Your ref 3/2012/0137
Our ref PG/EVP/ER/3/12/8403/LK
Date 11 April 2012

**APPLICATIONS NUMBER 3/2012/0137, 0138 & 0139
FISHES AND PEGGY HILL FARM, HENTHORNE ROAD, CLITHEROE,
BB7 3BY
GRID REFERENCE 372653 439551**

Cubicle Building and associated Concrete Apron

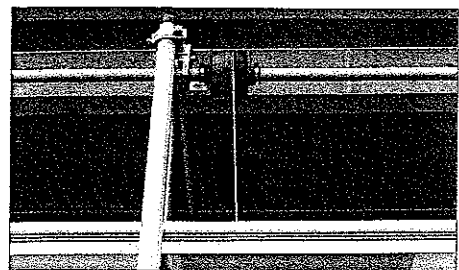
The design of the building is in accordance with the intended agricultural use and is a purpose built building. The inclusion of a ventilated ridge and cable driven curtain wall system on the east and west elevation would provide good ventilation through the building. The cubicle type accommodation proposed is typical for this type of farming enterprise and is, in my opinion, suitable.

The size of the proposed building is in proportion to the proposed increase in cow numbers within the tenant's herd, providing an appropriate area for cows to rest and feed.

The proposed building would be situated to the west of the existing cubicle buildings on the western side of the existing slurry tank

It is my opinion, due to the limitations of the farmstead, that the proposed building is situated in the most appropriate position relative to the existing accommodation and dairy/parlour.
